SUBMISSION TO DEPARTMENT of PLANNING and ENVIRONMENT

St Catherine's School Master Plan (SSD 6339) **29 Albion Street, Waverley**

WAVERLEY TRAFFIC COMMITTEE RECOMMENDATION

TRAFFIC MANAGEMENT AND PARKING

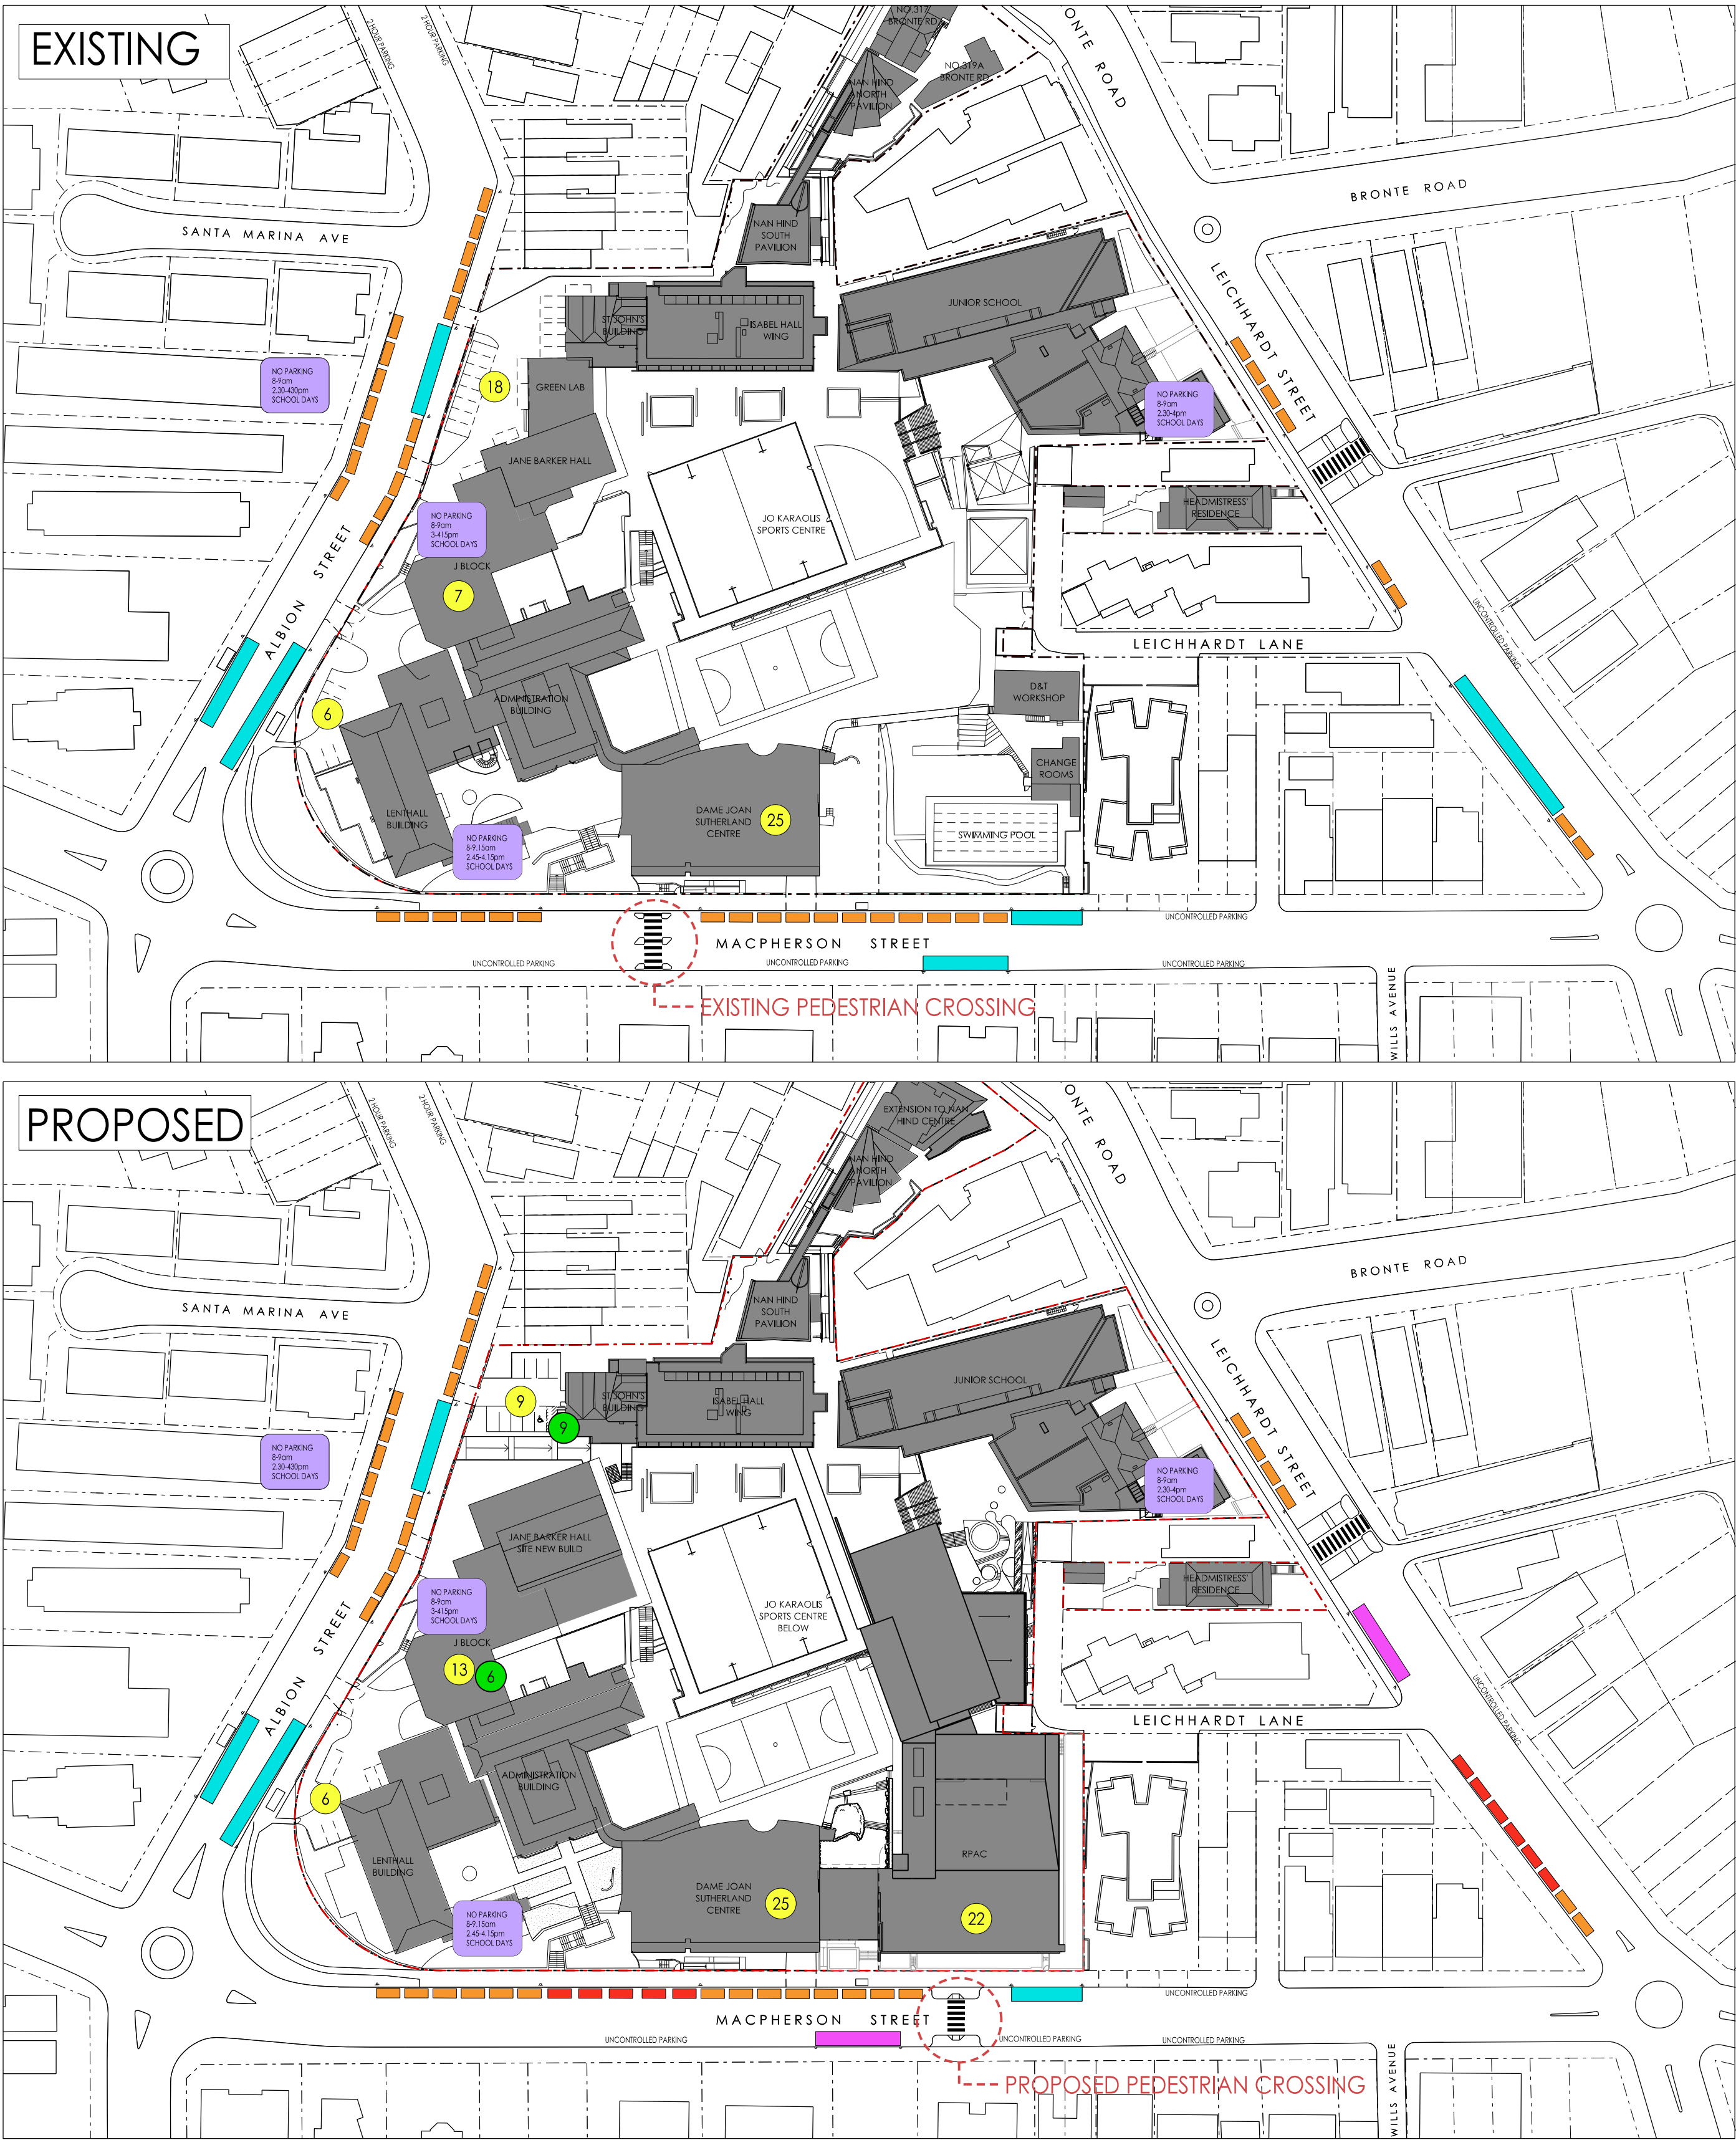
1. The Master Plan be amended to provide a substantial amount of additional on-site parking, for example a minimum of 200 car spaces - currently only 19 extra car spaces are proposed in addition to the existing 56 car spaces. This is essential due to, but not limited by, the:
 - (a) Existing over-subscribed on-street parking in the area
 - (b) Proposed increase in capacity of the school, including students, teachers, staff and visitors, and
 - (c) Proposed intensification of school functions associated with the new buildings, including the 500 seat theatre and large aquatic centre.

The development of the RPAC should be dependent on providing the additional parking, that is, the parking should be physically provided with the first stage of development.

4. The existing driveway on Macpherson Street being widened at the car park entry and on Macpherson Street to cater for full and unimpeded two way operation and improve driver sighting of pedestrians.
